PCD PM-FAE Comments.pdf Markup Summary

Subject: Callout
Page Label: 1
Author: CDurham
Date: 7/24/2026 12:39:50 PM
Status:
Color:
Layer:
Space:

(TB) TOPSOIL BERM (INITIAL/INTERIM)
(ST) SEDIMENT TRAP (INITIAL/INTERIM - PREVIOUSLY INSTALLED BY OTHERS)
(TSB) TEMPORARY SEDIMENT BASIN (INITIAL/INTERIM - PREVIOUSLY INSTALLED BY OTHERS)
(VEG) SEEDING (FINAL)
(GRV) GRAVEL (FINAL)
T/P TRACKING PAD (INITIAL/INTERIM)

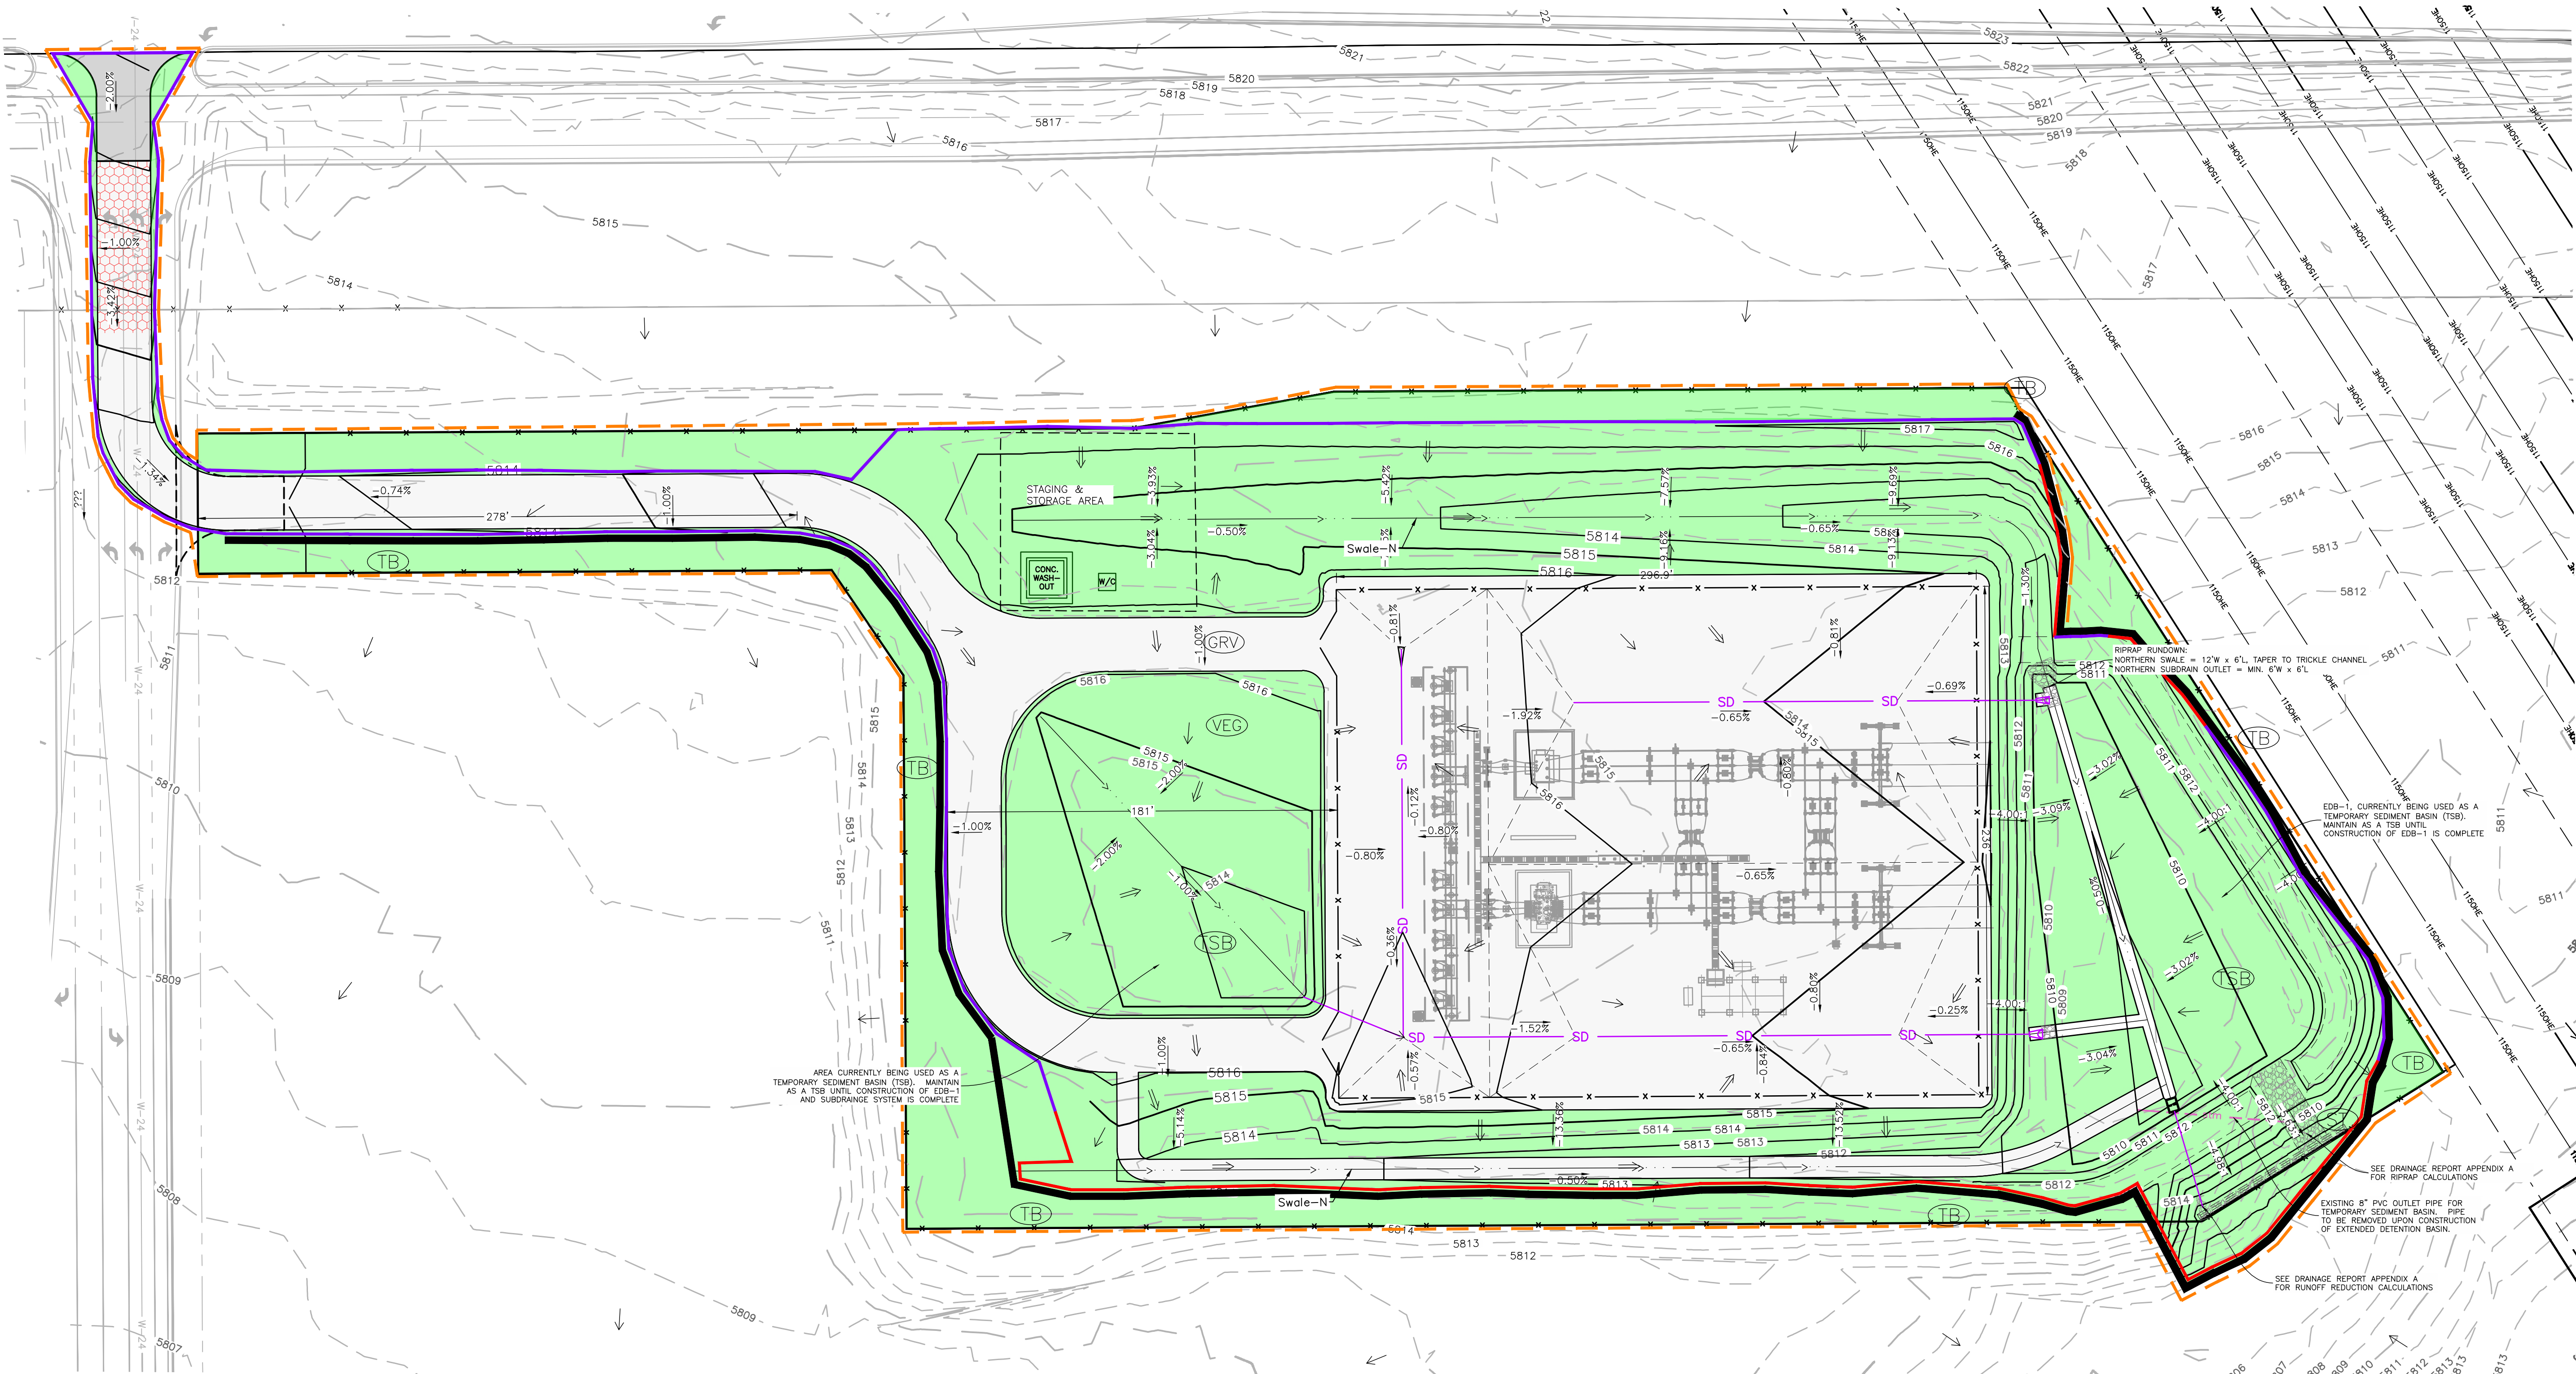
Include quantity

DMC RESPONSE: Quantities revised. Quantities added for existing sediment trap and temporary sediment basins. The existing silt fence has been removed from plans and will be maintained/removed by others.
